Application number: 2023/93714	
What is the application for?:	Reserved Matters application (including the consideration of access, appearance,
Address of the site or building:	Land off, Cumberworth Lane, Denby Dale, Huddersfield, HD8 8RU
Postcode:	S36 4HG

Type of comment: An objection	
Do you wish your comments to be published on the website anonymously?	Yes

Section D-D As Proposed
Scale 1:100

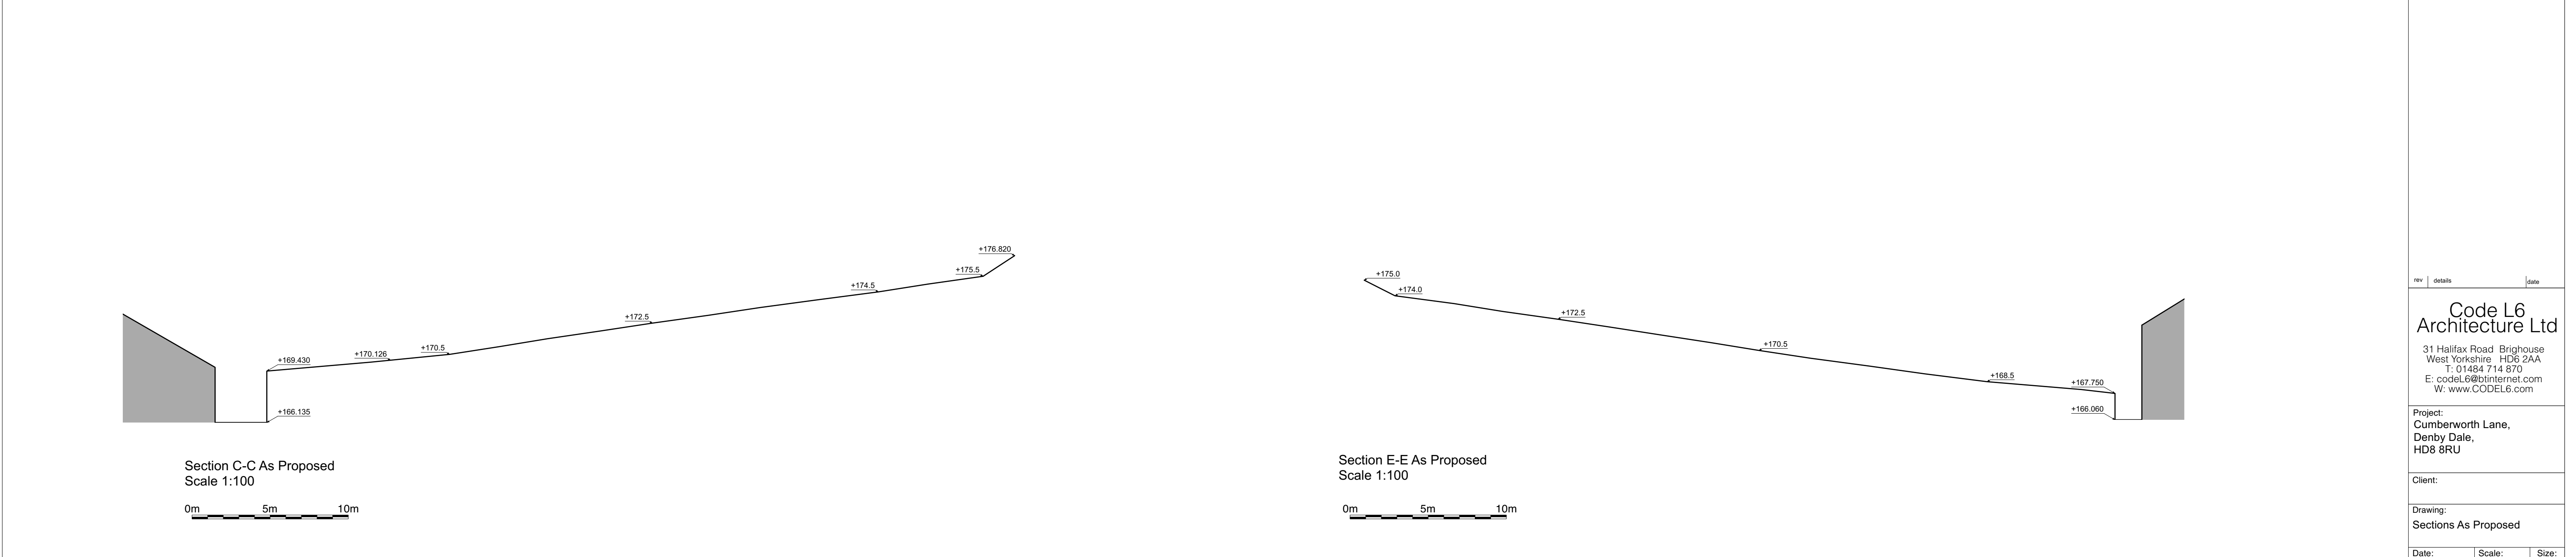
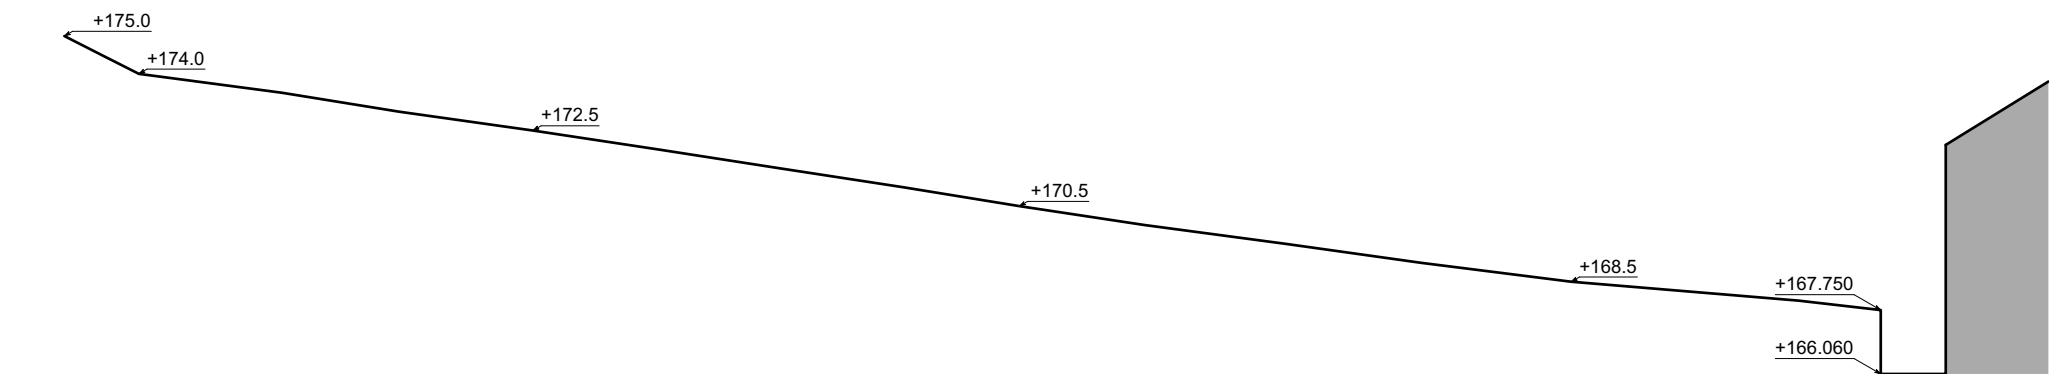
We believe the application does not comply with Policy LP5 (c), or Policy LP24(a) of Kirklees Local Plan Adopted 27 Feb 2019 for the following reason: The height of the proposed road and properties, as shown on section DD is at an elevation providing direct views into our upper floor windows with no attempt in the landscape proposal to mitigate this. We believe the development should be set into the hillside rather than built out as this would integrate it better into the landscape and be less intrusive to the properties below. Furthermore, this would reduce the height impact of the proposed 3 story properties adjacent to Cruck Cottage which we consider inappropriate as they would extend above the ridge line of that property.

A section between CC and DD would be useful so we can understand the interaction with our boundary and the development at this location. Our assumption is that the gardens shown are at grade , but this is not clear within the information provided.
